DECISION DELEGATED TO DEVELOPMENT MANAGER

Application No:	H22-0685-20	Applicant:	Spalding Developments
Proposal:	Residential development (maximum 3 single storey dwellings)		
Location:	Rear Of 192 To 200 High Road Weston Spalding		
Terminal Date:	9th December 2020

1 Proposed Block Plan
1 : 500

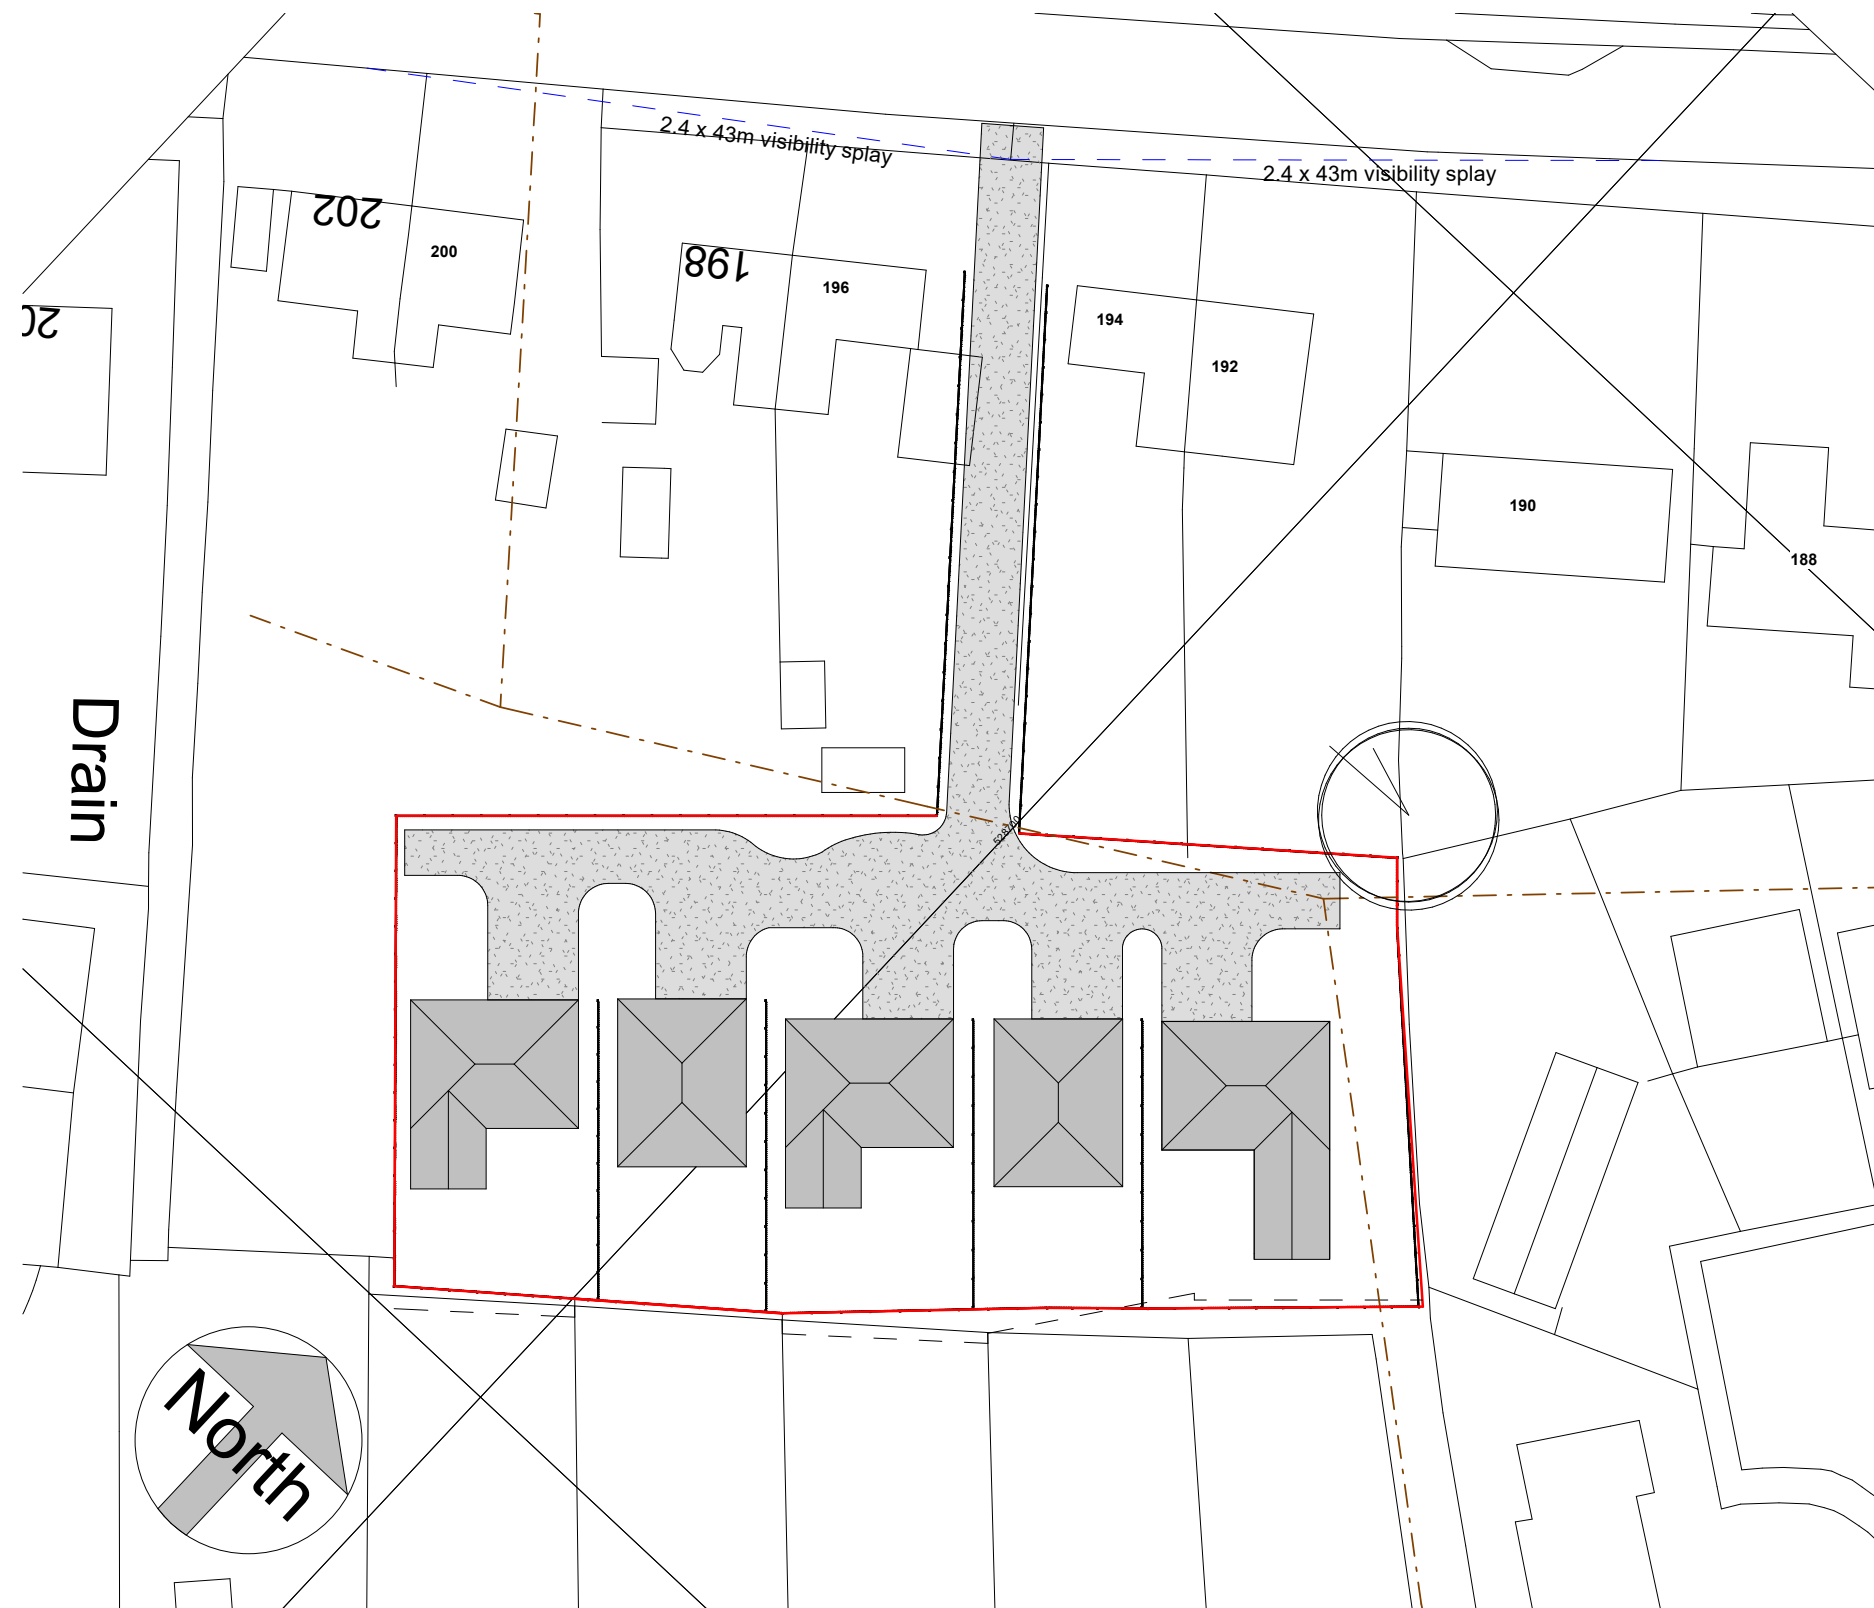
Concerns have been raised over alleged encroachment onto neighbouring land and also maintenance rights. The former has been taken up with the agent who has indicated the following:

"We have updated the location plan and block plan to the boundary shown on the OS map so it no longer looks like it is going over the boundary. I think this is more of an issue of the inaccuracy of OS maps as the site plan is based on an accurate topographical survey within existing defined boundary fences."
